From: Simon Davis
Sent: 02 December 2019 17:14
To: Mark Warwick <Mark.Warwick@arun.gov.uk>
Subject: FW: Inglenook P/58/19/PL

At the request of WSCC Highways (see comments attached – top of page 2), the applicants are proposing to remove two conifers from the access road (see annotation on the plan). These are also shown on the photo. They state in the email below that the trees are Category C. Can you confirm whether this is ok with you? I could do with knowing by the 10th December so that I can get this included in the Committee report.

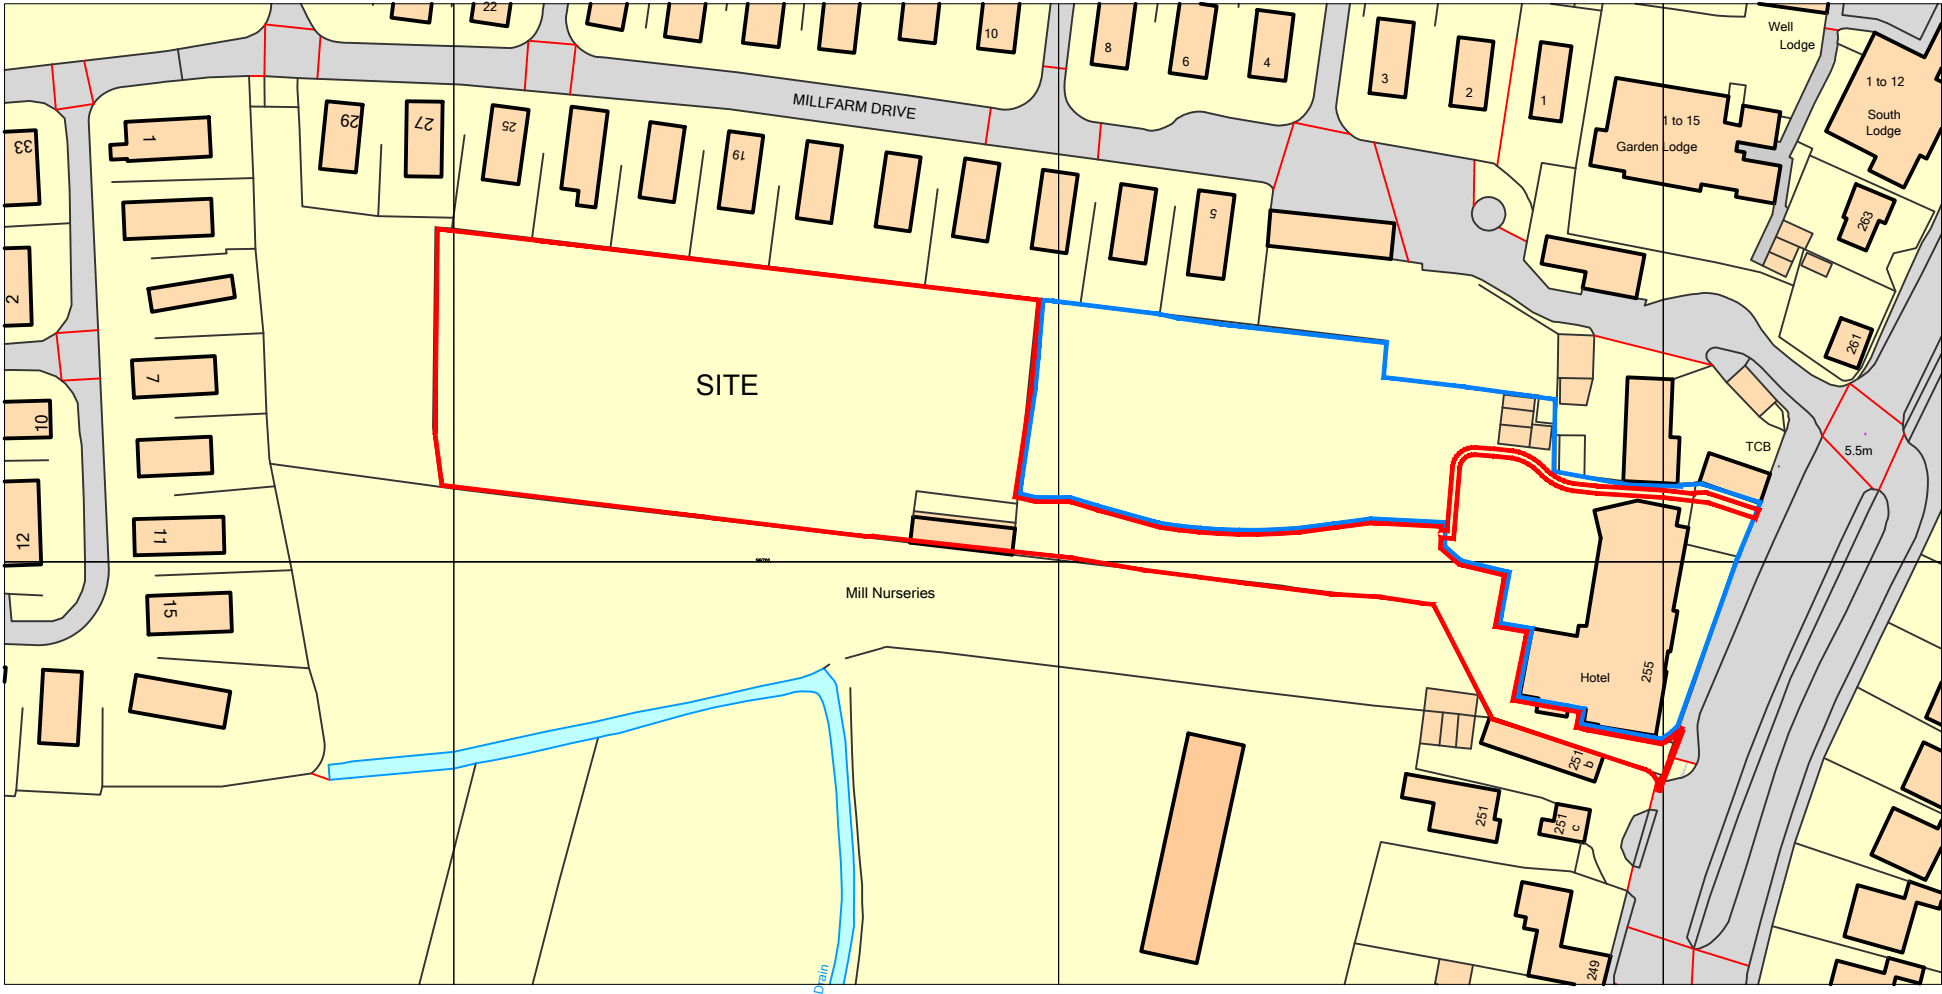
Attached is a photo of the corner in question. The dead branches laid to make a kind of fence can be removed. The conifer tree can also be removed to leave the two sweet chestnuts free-standing. If we propose to remove the conifers, would it be sufficient for this to be identified with a new annotation on the site plan? The tree report identifies them as C Category trees and we cannot see a reason for retaining them.

With regards to your questions, we can confirm that the understorey vegetation around the trees will be removed and any side shoots or whippy growth coming from the sweet chestnuts kept trimmed to maximise visibility. There is a mixed Leyland and Lawson cypress hedge that extends to this corner; it is not very attractive and not locally characteristic. If your tree officer is in agreement, a section of this could be removed from the corner area to further improve visibility.
